# Rezoning Transportation Analysis

Petition Number: 2023-176

**From: Jake Carpenter, PE**

Date	Description
01-23-24	First Review (IW)
02-21-24	Second Review (IW)

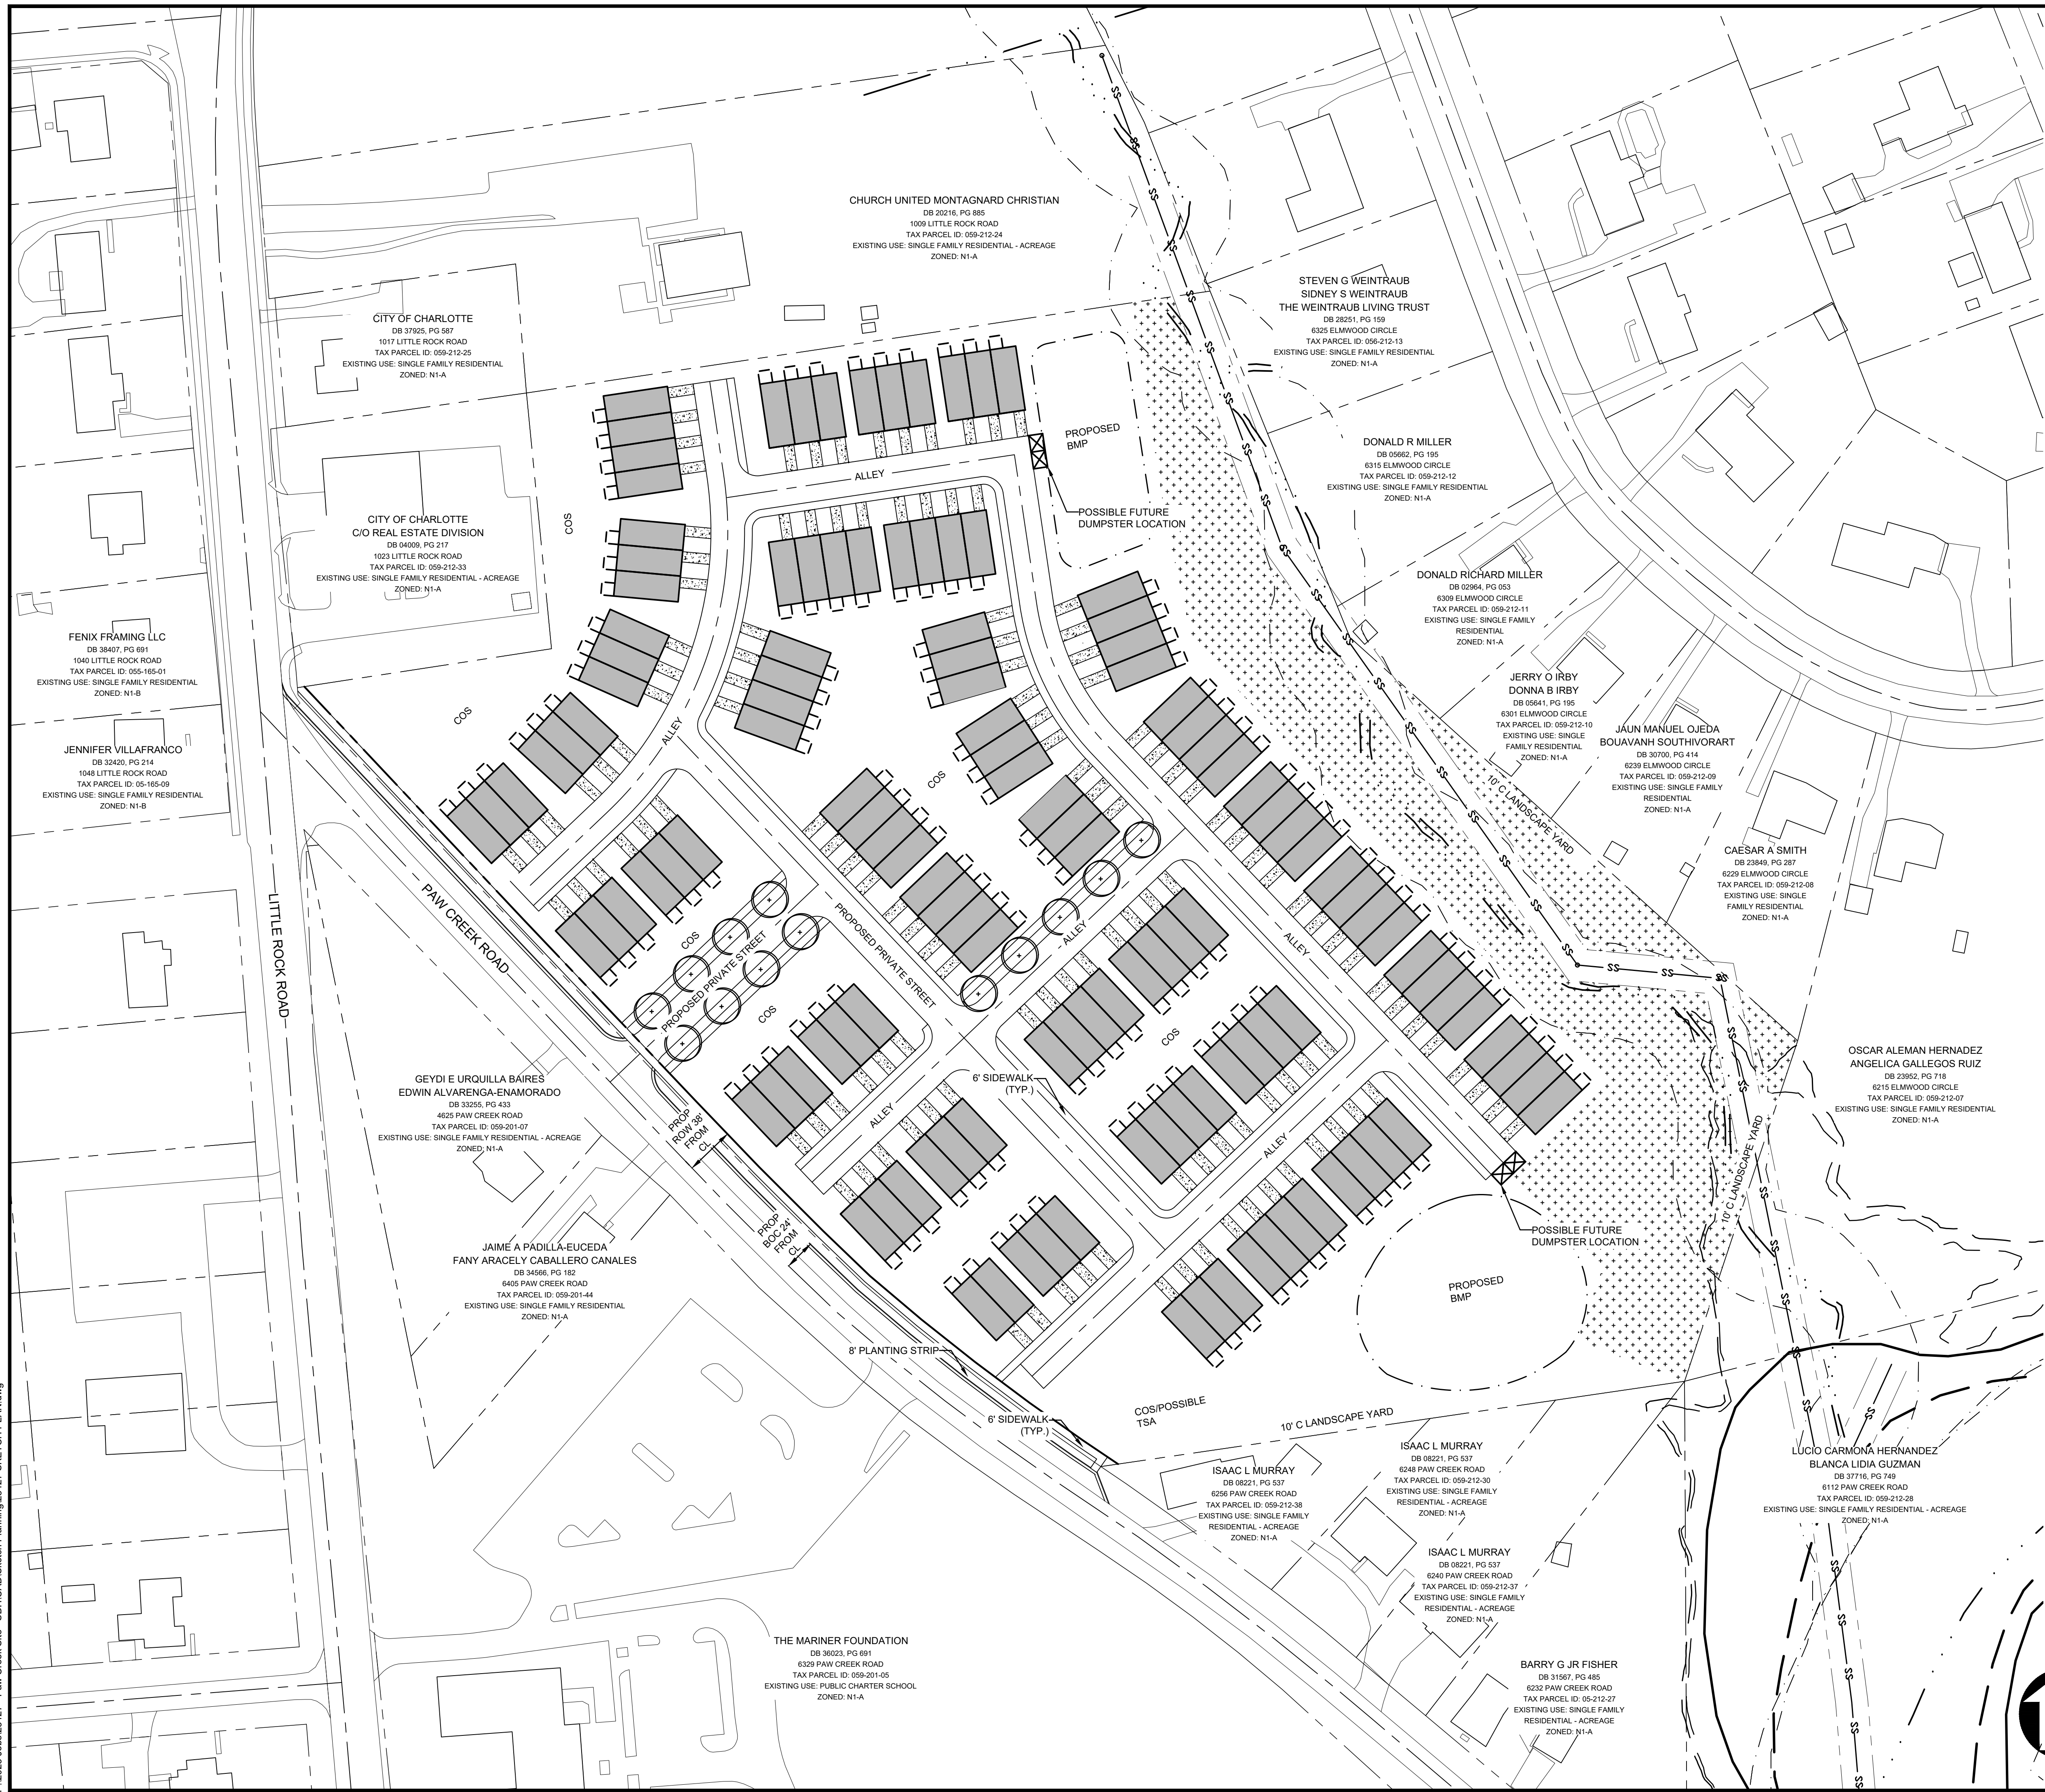
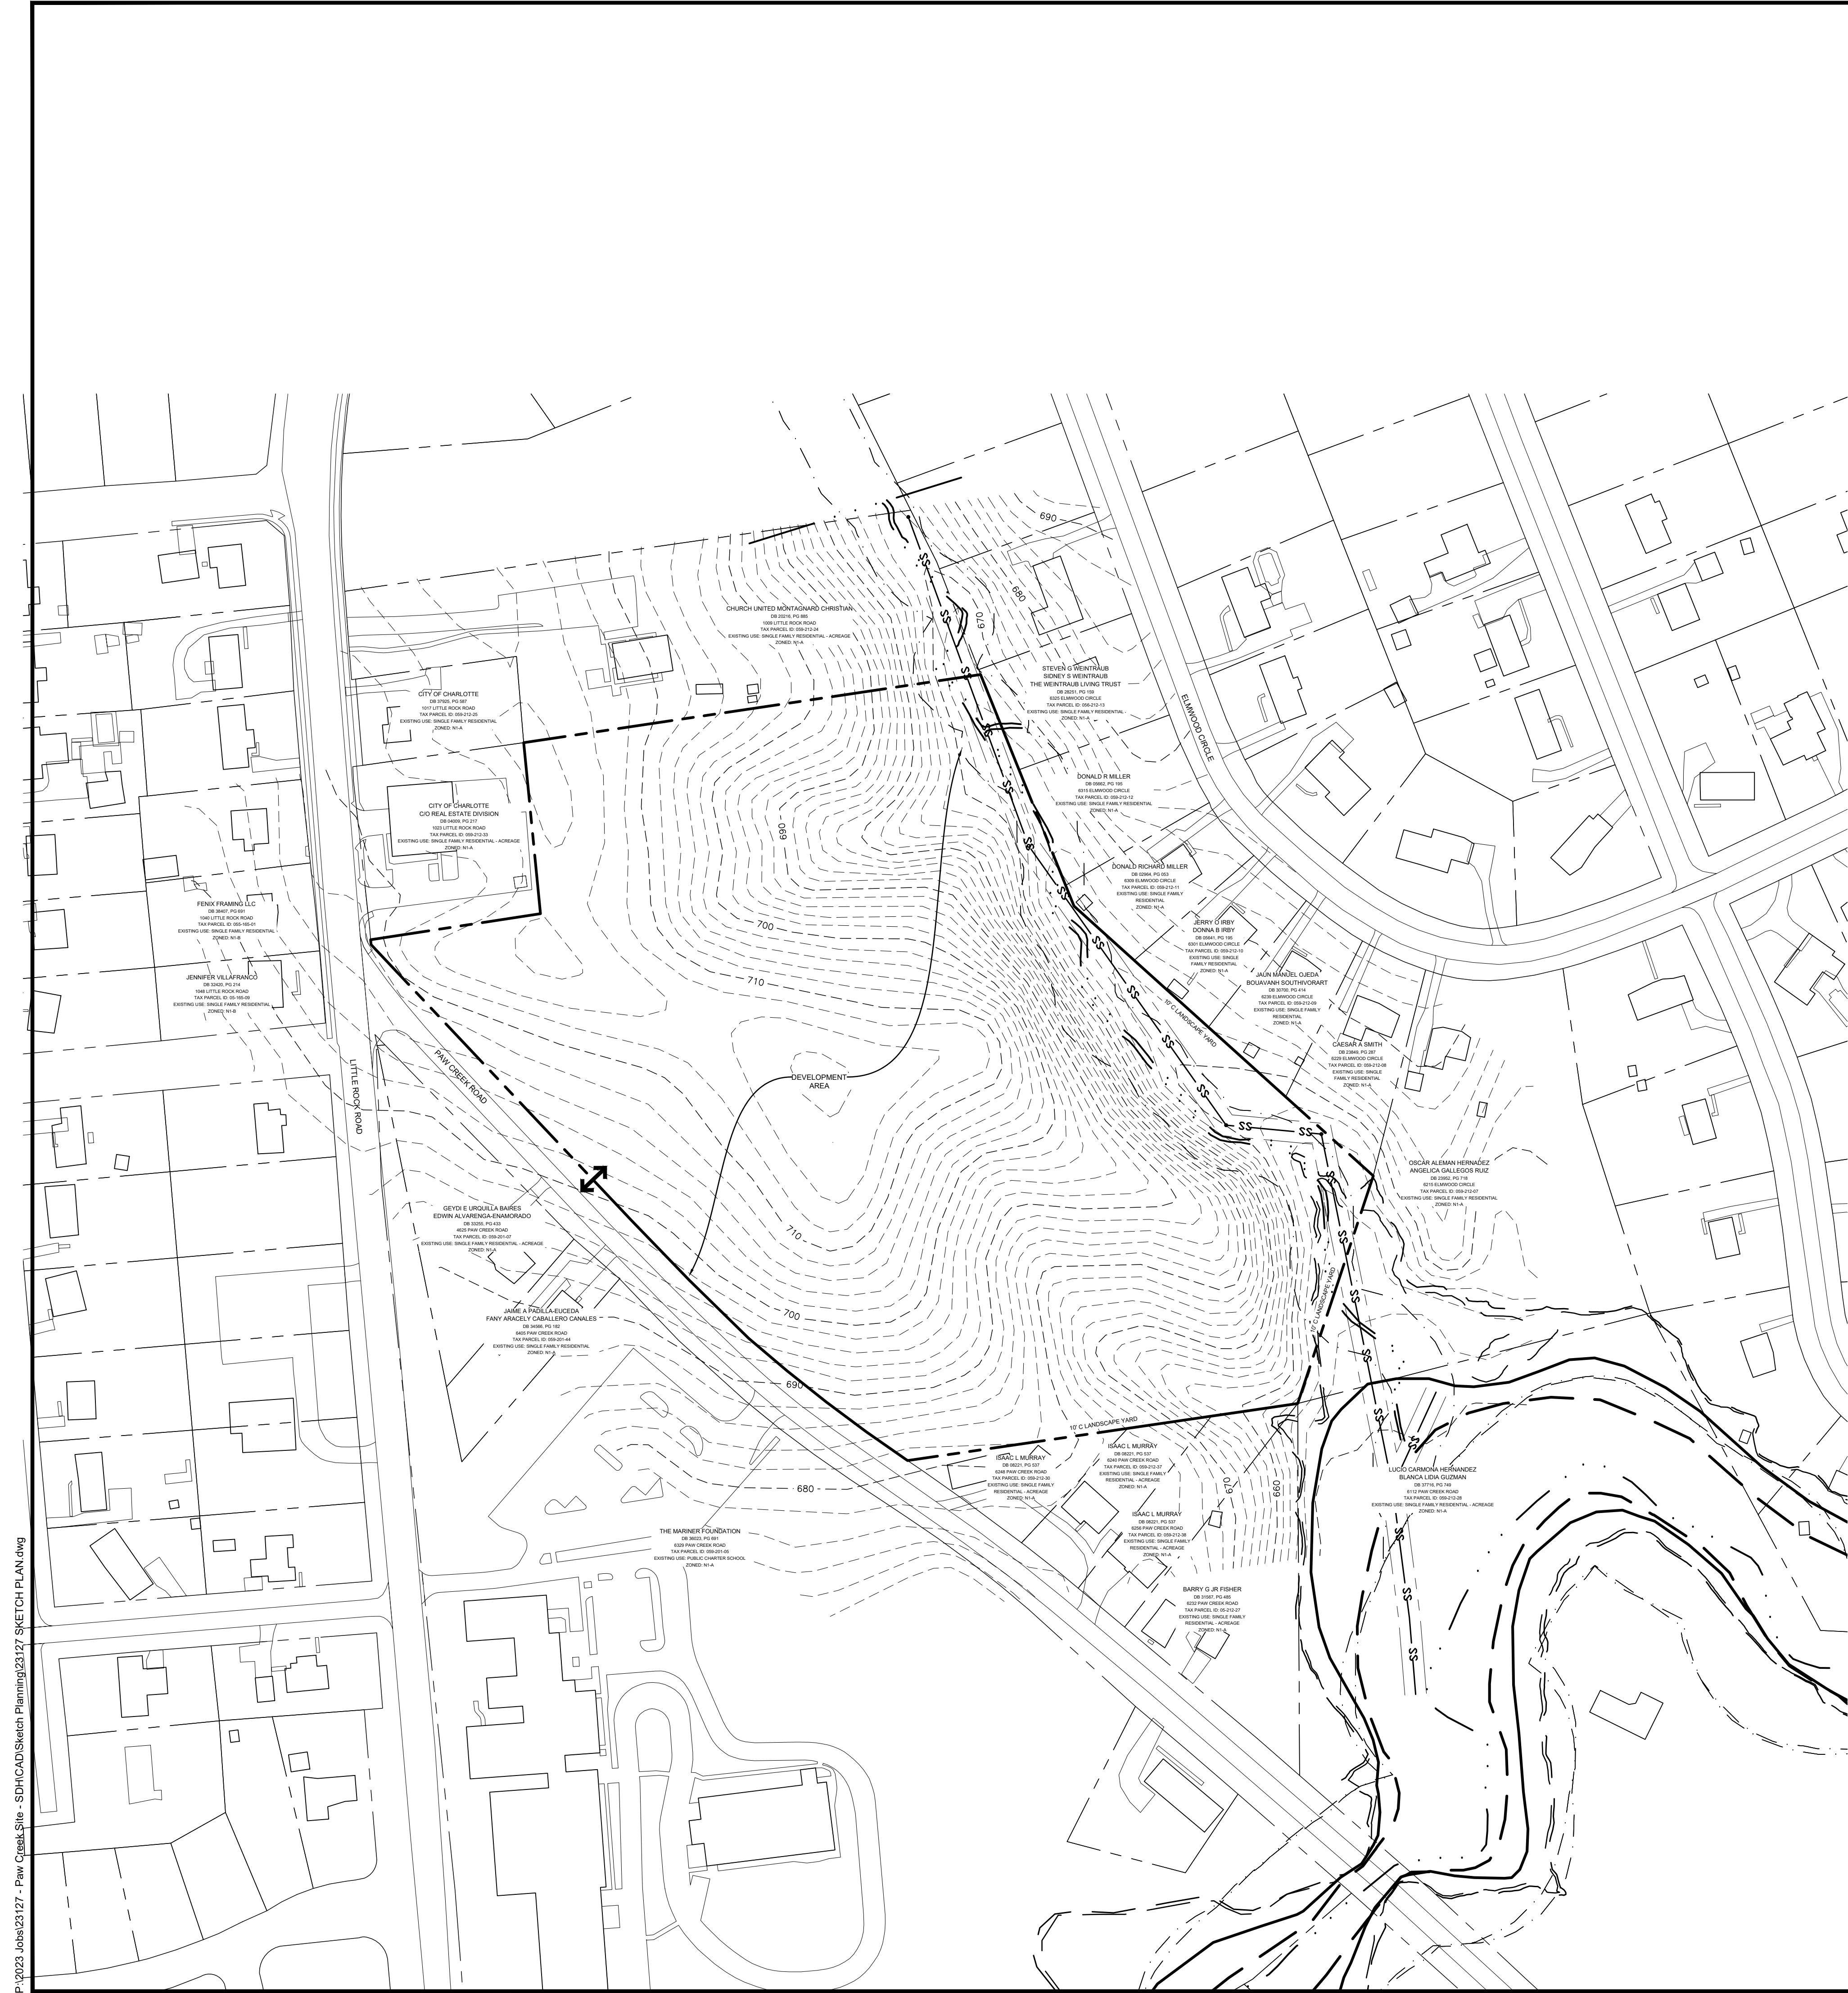
~~a. **Paw Creek Road:** Location of future back of curb and gutter to be moved 24' from Centerline.~~

~~2+ Avenue, Bike Lanes per the Charlotte Streets Map~~

~~Label and dimension the curb and gutter from the centerline for each road on the site plan.~~

The petition's zoning falls within the low intensity development which based on the 917 daily trips will trigger Tier 1 (3 mitigation points) for multimodal assessment. The petitioner shall review and assess the publicly accessible pedestrian network within ¼ mile walking distance of the site to identify multimodal infrastructure to meet the Tier 1 (3 mitigation points) for multimodal assessment.

**Clarifying comment 02.21.24:** See Table 3.3 Multimodal Assessment Mitigation Options in the Charlotte Streets Manual for guidance. Complete CTR summary table and include on the revised plan. CTR table link (use Site Data Table – CTR Summary tab): <https://www.charlottenc.gov/files/sharedassets/city/v/2/growth-and-development/documents/dev-center-fees/resources/udo-site-data-tables-curb-ramps-and-ctr.xlsx>

~~3. Revise site plan and conditional note(s) to commit to dedicate 38' of right of way from the road centerline. The site plan shall label and dimension the right of way from the road centerline.~~

~~Update conditional note III.5. to remove the word "offsite" as all public transportation infrastructure will need to be completed prior to first CO which includes sidewalk along Paw Creek.~~
